File No: SSD 9275  
Our Ref: R/2018/27

**State Significant Development SSD 9275 – Student Accommodation – 80-88  
Regent Street, Sydney**

## ATTACHMENT A

Level 01

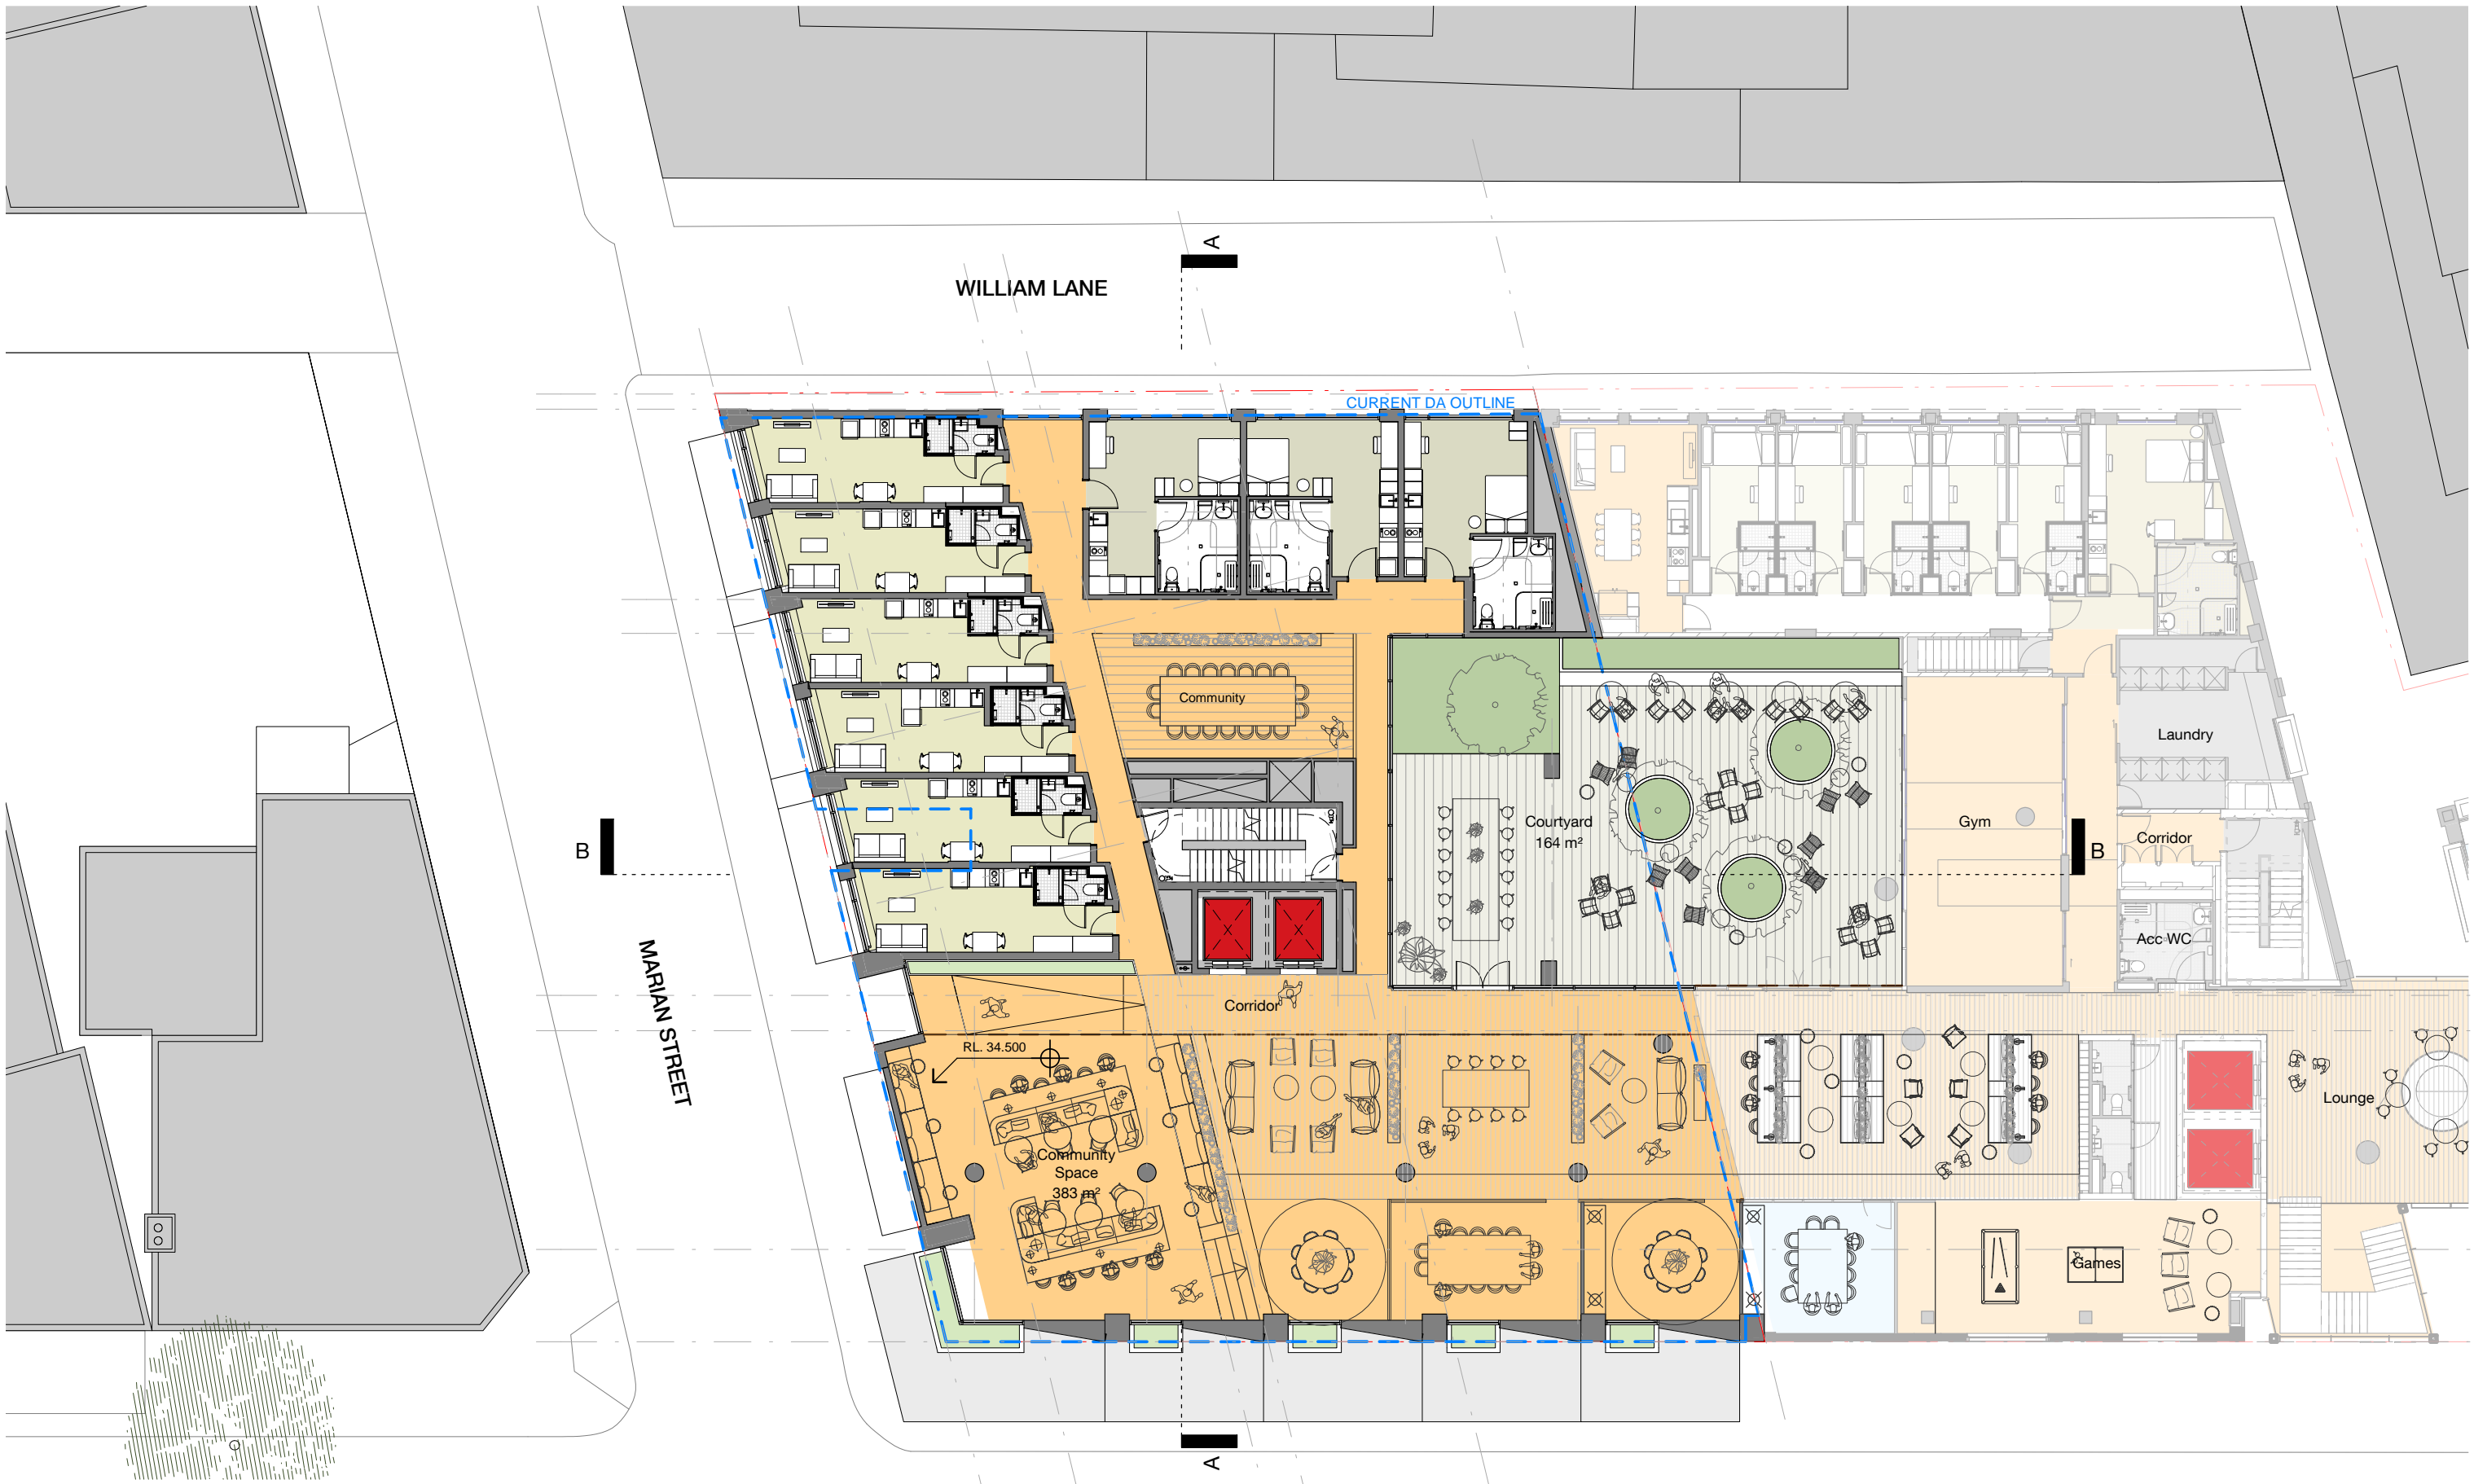
The design of the podium fenestration requires further consideration / justification. The large blank section of brickwork at Level 1 to Marian Street is uncharacteristic in the local context where the upper level presents an opening to the street, particularly at corners. The plan indicates seating immediately behind the blank wall – there is no reason why this cannot also be glazed.

The principal area is located on Level 1 is partly covered by the floor above, and provides 88m<sup>2</sup> area, of which only 66 m<sup>2</sup> is considered useable open space.

The entire area is located on slab over bike store and a “comms rooms” below, and the design is intends to integrate or join with an existing common terrace located to the north.

The proposed common open space (within this site) is enclosed by glazing to 3 sides, open to the sky, and connected to indoor lounge rooms, a nearby community dining table and community space. Noting the later appears to be designed for the exclusive use of the students rather than the local community. The design of common open space provides timber decking, a large communal table, loose furniture and planters. There is no BBQ or fixed furniture proposed.

Ideally the design and location communal open space responds to site conditions and the location of facilities responds to microclimate, with access to sun in winter, shade in summer, shelter from strong winds and down drafts. However, the design results in significant wind issues requiring specific wind mitigation measures that are not shown on the architectural or landscape plans – refer to other comments below.

The architectural and landscape plans are not coordinated with the wind report recommendations and the location of the door to the courtyard and communal table may need revision.

- the design of the Level 1 communal open space be reviewed to achieve a minimum 50% soft landscaped areas, additional facilities and include wind mitigation measures for comfort;
- solar access be provided to communal open spaces to achieve compliance with DCP;
- clarification be provided on whether the furniture in the communal open spaces is fixed and if the space is lit at night;
- clarification be provided on the location of all trees on slab, and the soil depth and soil volume for all raised planters on all levels; and
- the planter heights be increased to provide adequate soil depths and soil volumes for the new development and compliance with the Sydney Landscape Code Volume 2.

Roof Terrace level

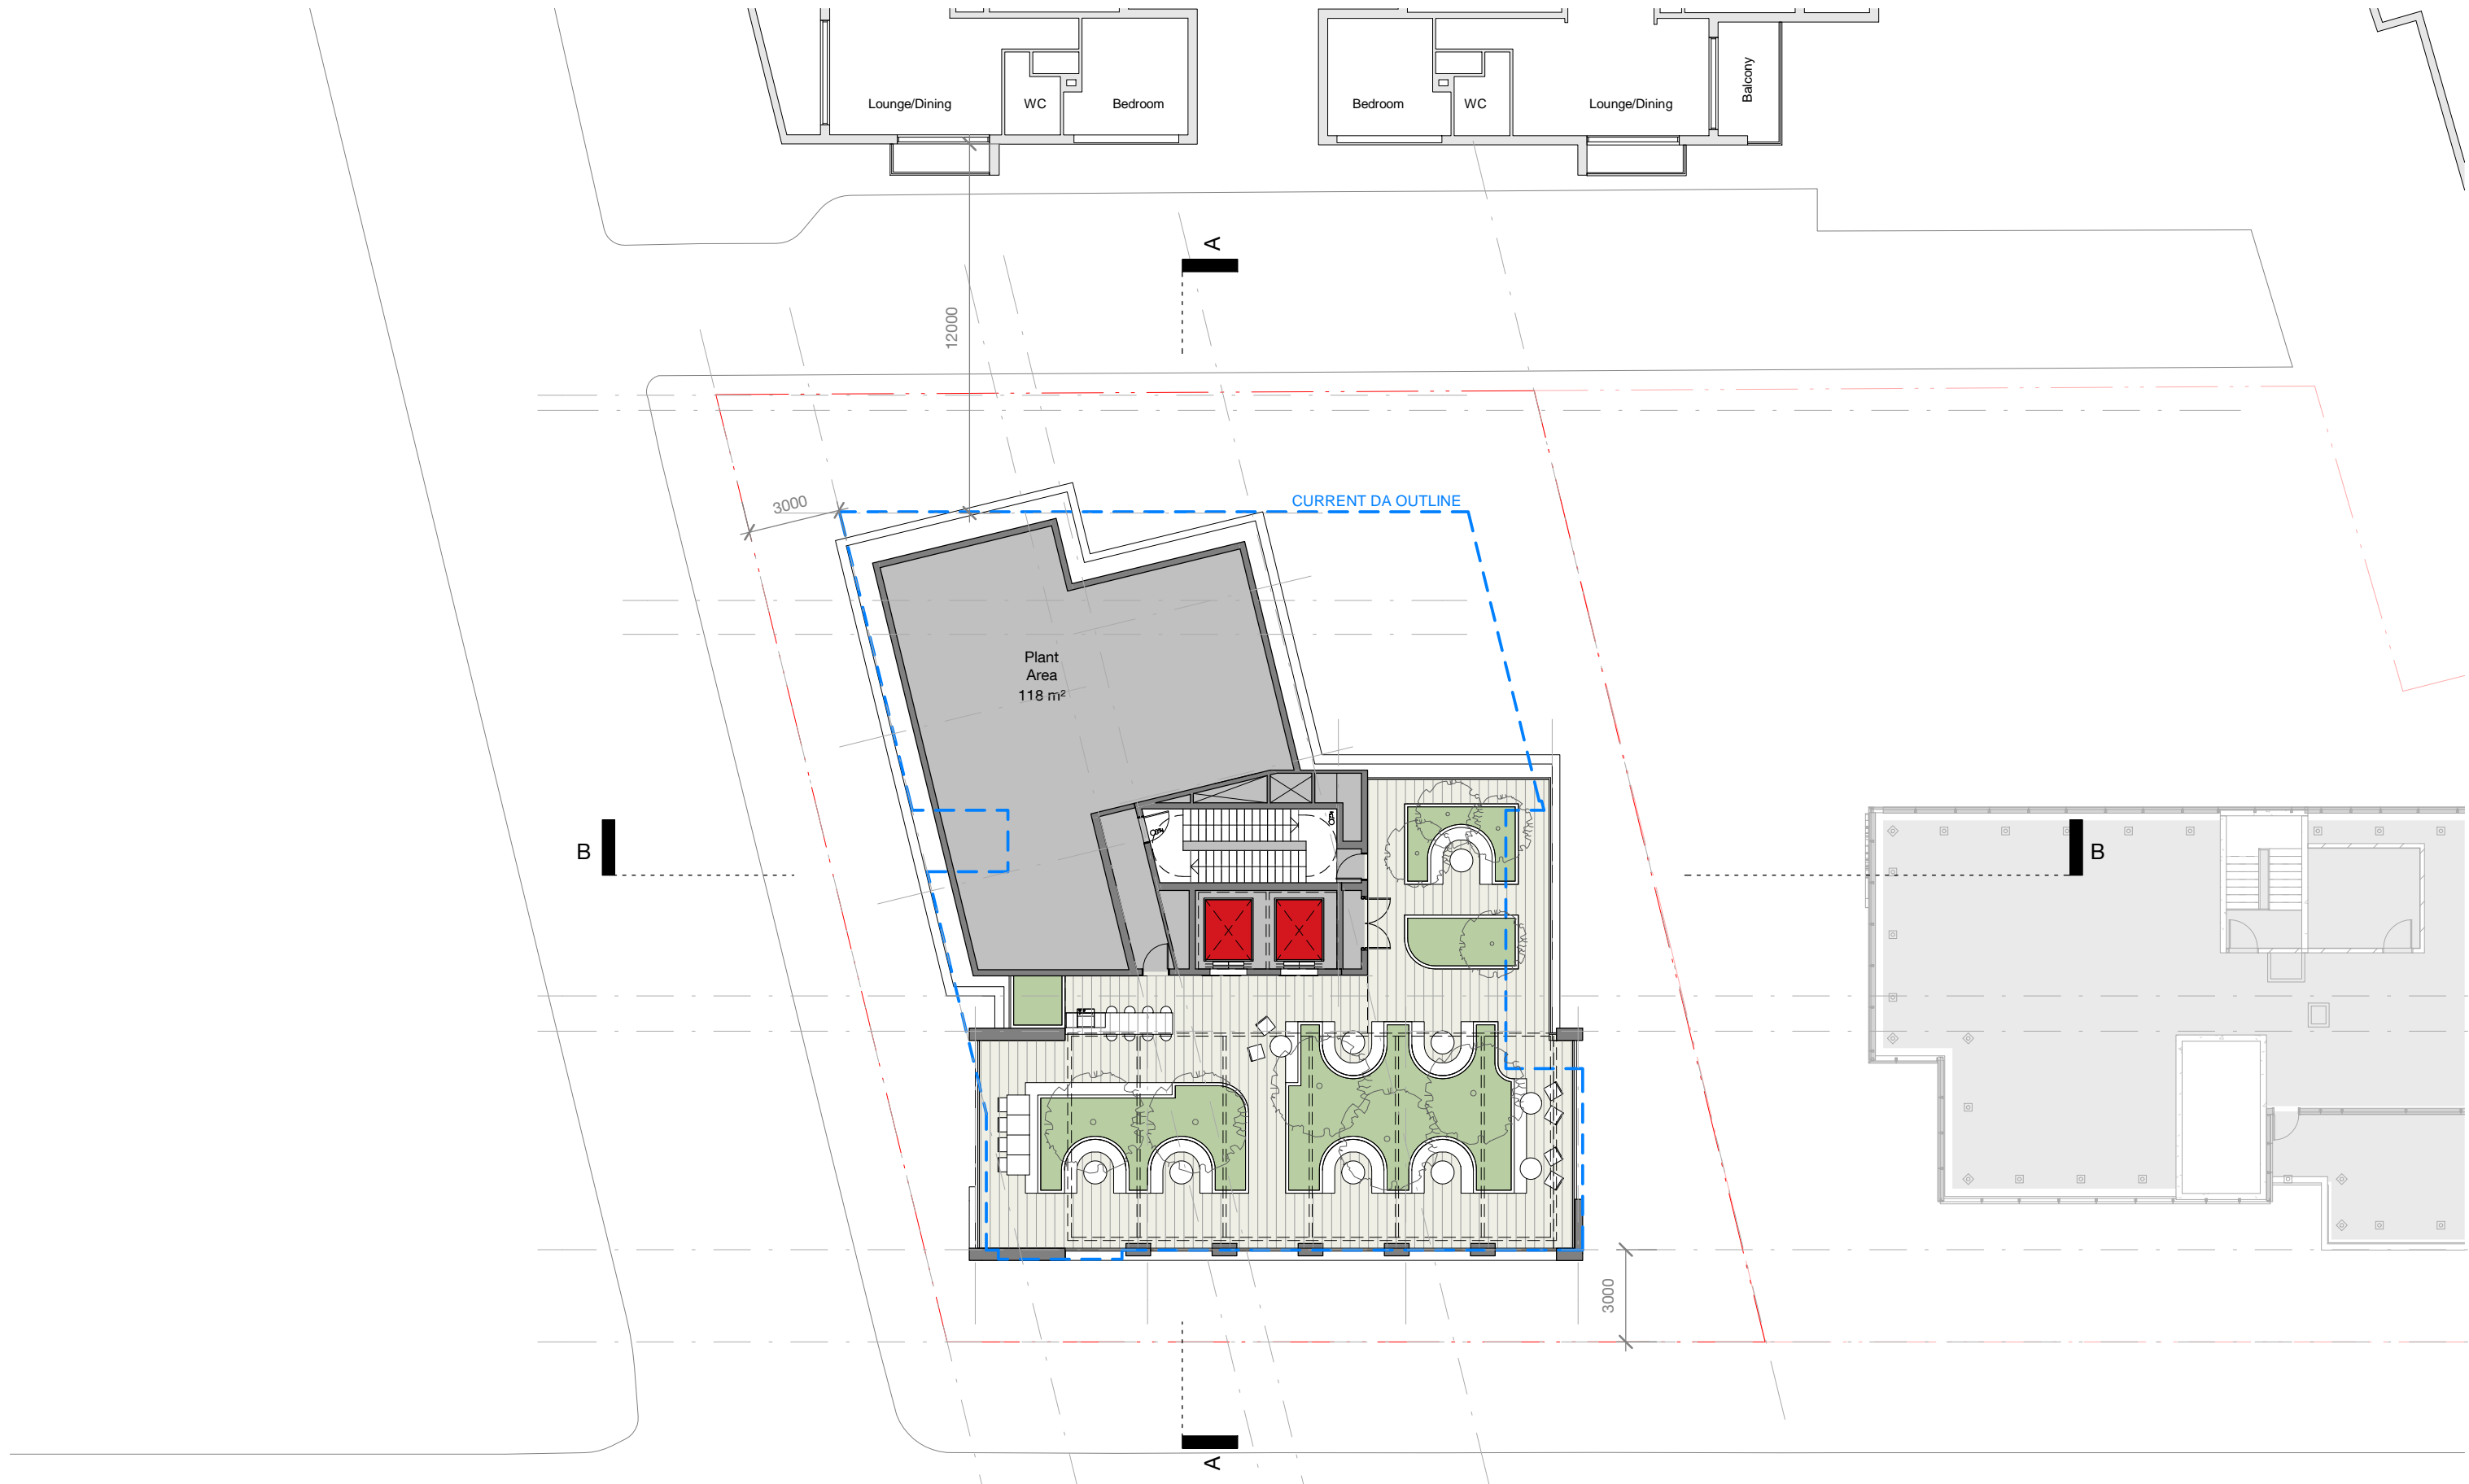
The proposal includes timber decking, a BBQ area with raised bar and seating, loose furniture under an awning, a grid of seating areas separated by raised planters with trees, a feature timber arbour with climbers and a glass balustrade and parapet to the terrace edge.

The terrace design is generally supported however planter depth and volume is problematic.

The raised planters with trees are only 800mm high with medium to large street tree species (*Cupaniopsis anacardioides*) which grows up to 15 metres tall and canopy spread of 15 metres in ideal conditions. The trees will be subjected to wind and exposure on the rooftop terrace. The plans submitted do not clearly show the location of trees, making it difficult to assess the soil depth and soil volume. The soil depth of planters is considered too shallow to support the tree on the roof top which to comply with the Sydney Landscape Code, a medium large tree requires a minimum soil depth of 1000mm and soil volume of 35m<sup>3</sup>.

Confirmation of the tree locations, soil volume and justification of why the planters cannot be increased in height to provide the minimum soil depths is required.

There is insufficient information provided for the arbour structure (design, height and maintenance), planting design, furniture fixings, lighting, and location of drainage outlets, irrigation and how the landscaping will be maintained.
